# Tween Bridge Solar Farm

## 9.4 Statement of Common Ground with the Environment Agency

**Document Reference: 9.4**

**Revision 1**

### Non-Intrusive Cable Crossing – Watercourse/IDB Drain/Main River/Canal

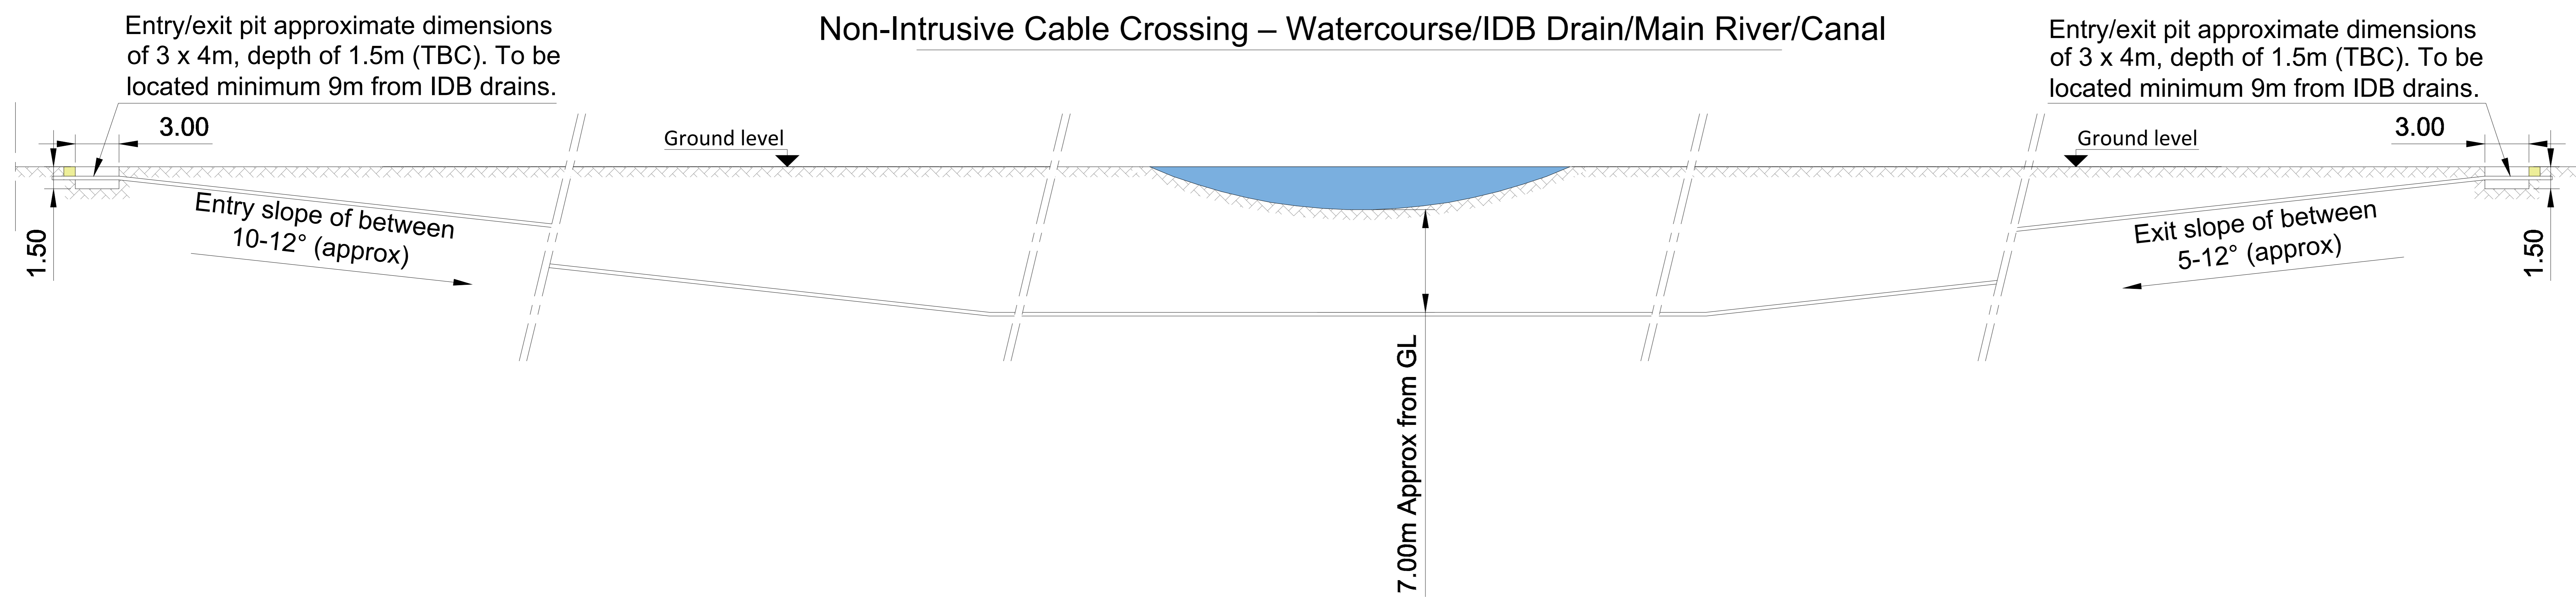
<p>other suitable alternative locations – sequential approach must be applied.</p> <ul style="list-style-type: none"> <li>Any cables crossings under Main Rivers are required to be directionally drilled.</li> <li>Requirement to compensated for any displacement of flood waters.</li> </ul>
August 2023	Email Consultation	Updated Tidal Trent model data requested from the EA following advice that more recent flood model data covering the site was available.
October 2023	Email Consultation	Non-statutory consultation request from the Applicant sent to the EA. Scheme and Online Webinar details provided to the EA.
November 2023	Email Consultation	<p>Non-statutory consultation comments received from the EA. The EA requested flood mitigation measures to be detailed in metres above Ordnance Datum and that mitigation beyond 1m of raising would be required, both of which have since been actioned. The EA flag the need to assess residual flood risk in the context of the Isle of Axholme Critical Flood Level. The EA noted they do not consider use of bunds as flood defences on site to be appropriate.</p> <p>The requirement for a sequential approach was raised by the EA, noting they would prefer Flood Zone 3b to remain undeveloped. The EA stated cable crossings below Main Rivers need to be directionally drilled. The EA noted they were satisfied with the proposals to date with regards to water resources and water quality. Information was also provided on biodiversity matters, the need for a Water Framework Directive (WFD) assessment, potential for electromagnetic impacts on fish from cables crossing under watercourses, land contamination and groundwater protection, waste management, historic landfill sites and battery energy storage systems.</p>
